**Re: Nusenda Credit Union at 6401 Uptown Blvd. NE
Erosion and Sediment Control Plan
Engineer's Stamp Date: 2/16/26 – H18E012 - (SWQ-2026-00013)**

Based on the information in your submittal received on 2/18/26, the ESC Plan can't be approved until the following comments are addressed.

**NUSENDA UPTOWN BRANCH  
TEMPORARY EROSION AND SEDIMENT CONTROL PLAN**

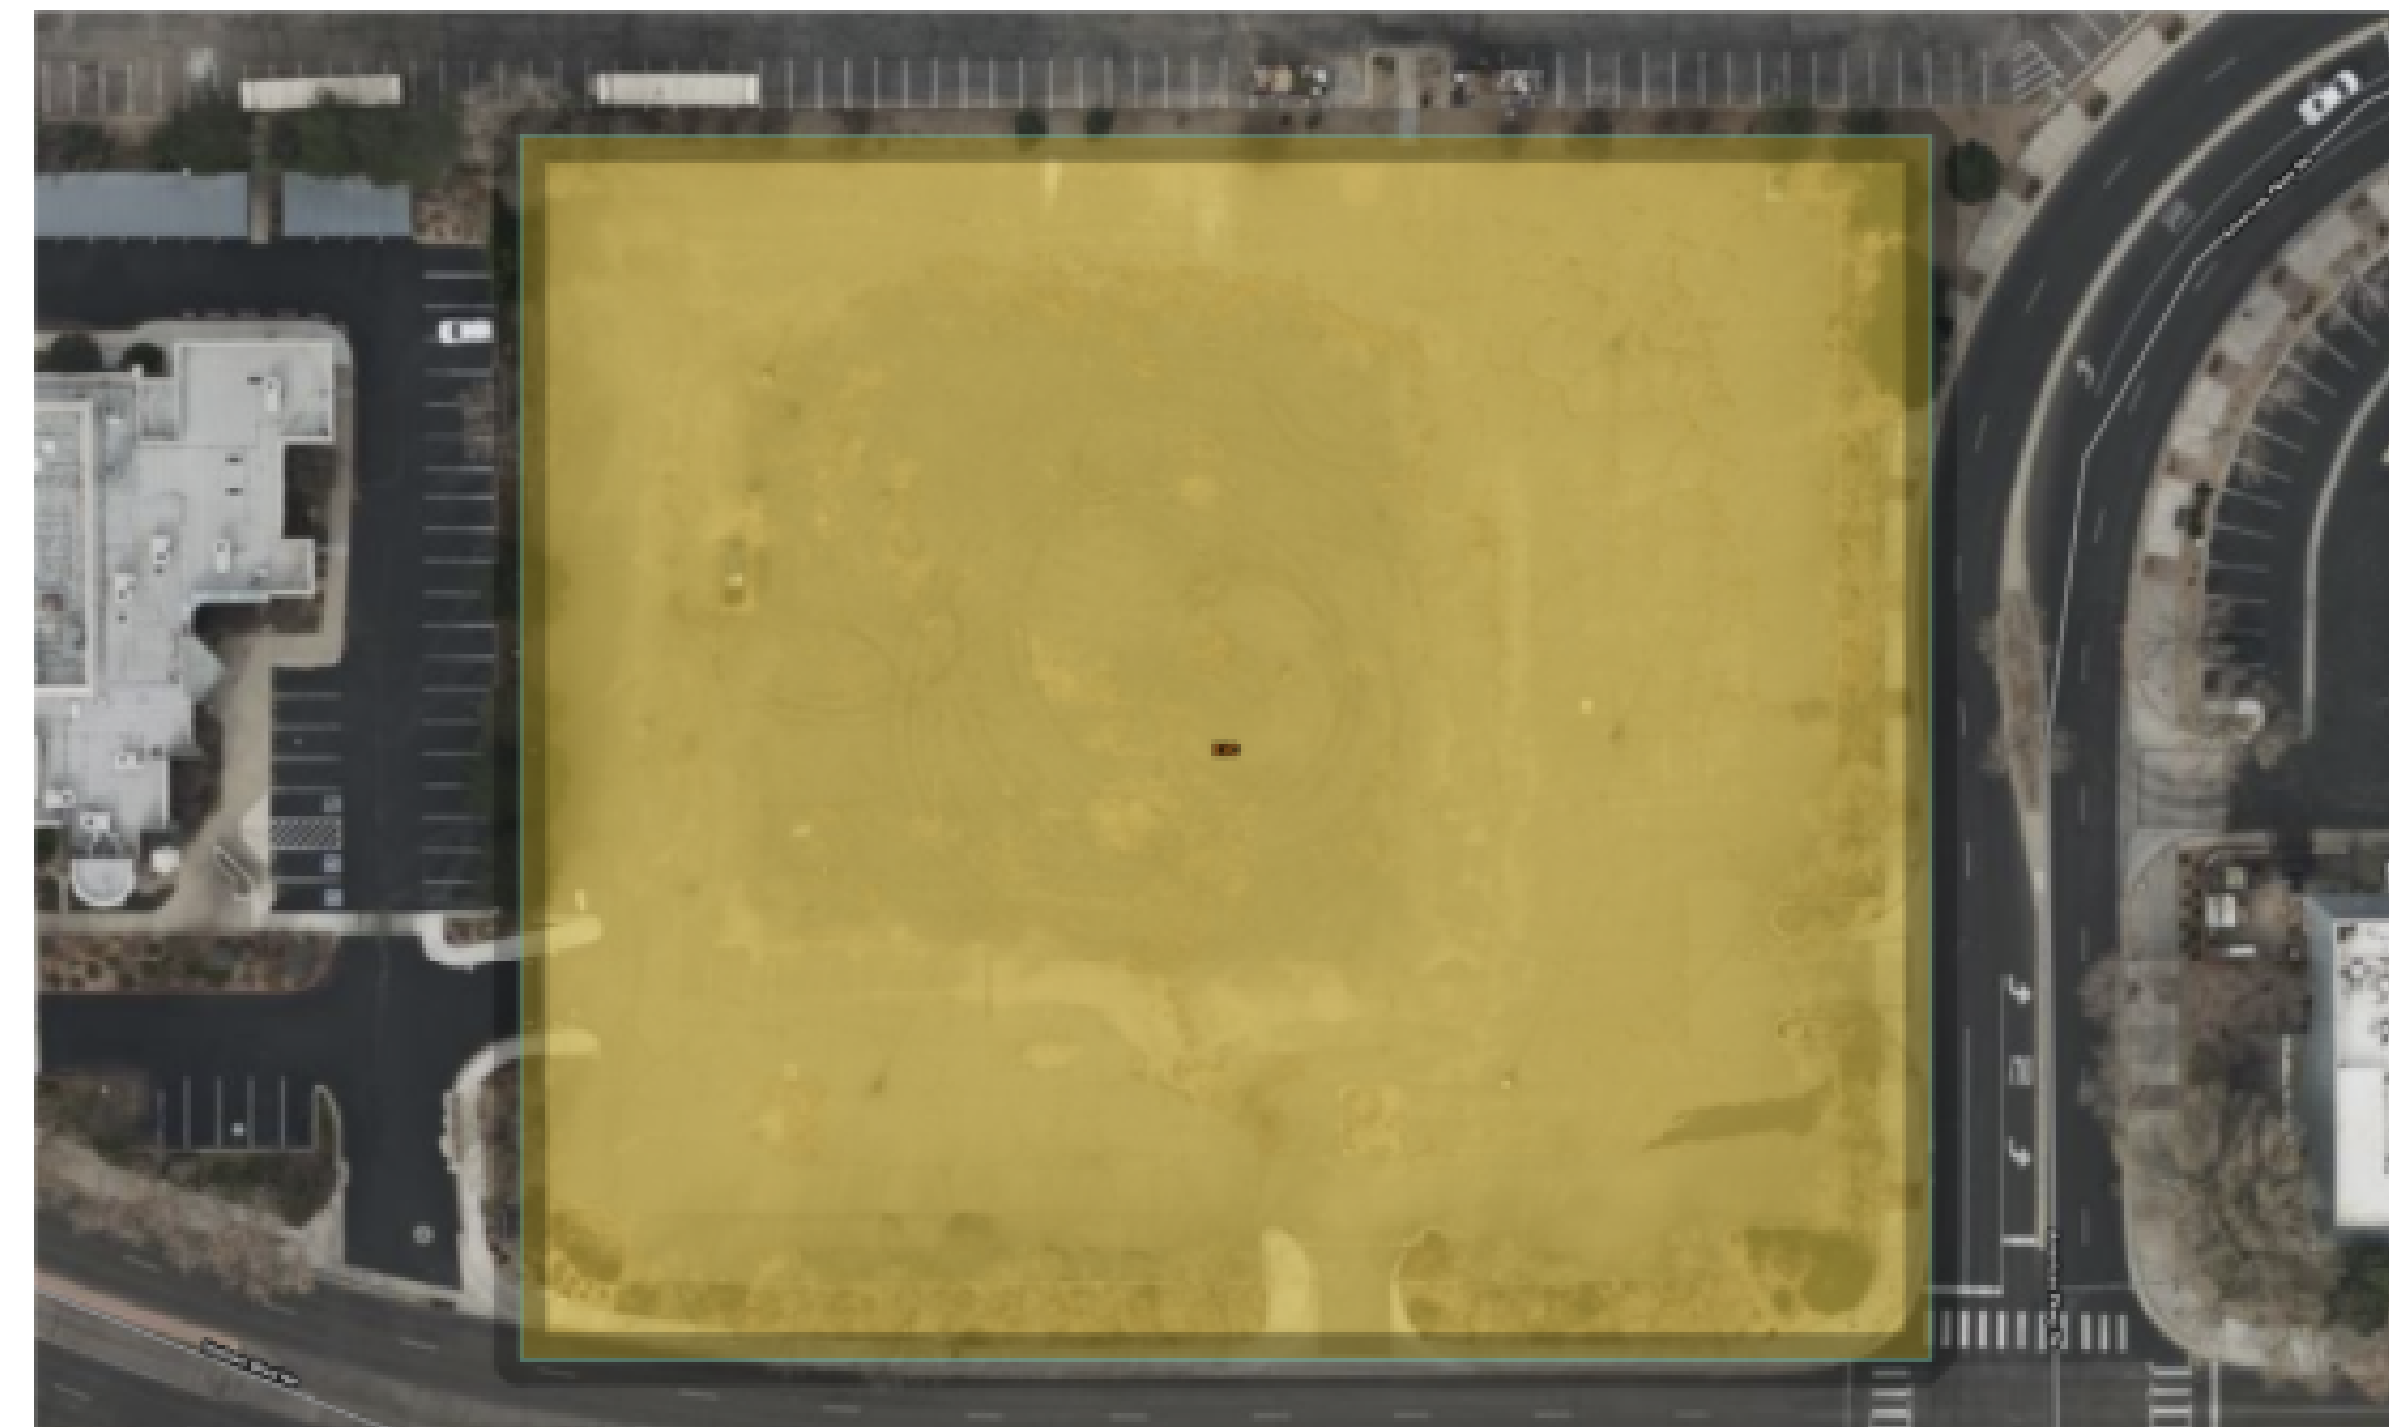
3. Stormwater Silt Fence (SWSF) design specifications say it must be on contour, but it is crossing contours on the ESC Plan. A Diversion Channel (DC) is typically used along a sloping contour to keep stormwater on site and convey it to a Sediment Basin or Sediment Trap (SB & ST). Add the city details available on the SWQ webpage and provide design calculations, construction specifications, and details on the ESC plan for temporary DC and ST.

4. The Construction Exit (CE) shouldn't be located on the low side of the site, as per the CE design specifications. The CE must be relocated to the high side of the site.

5. Provide a sequence of construction on the ESC Plan that shows these BMPs as the initial items of construction and requests their removal after construction and stabilization are complete.
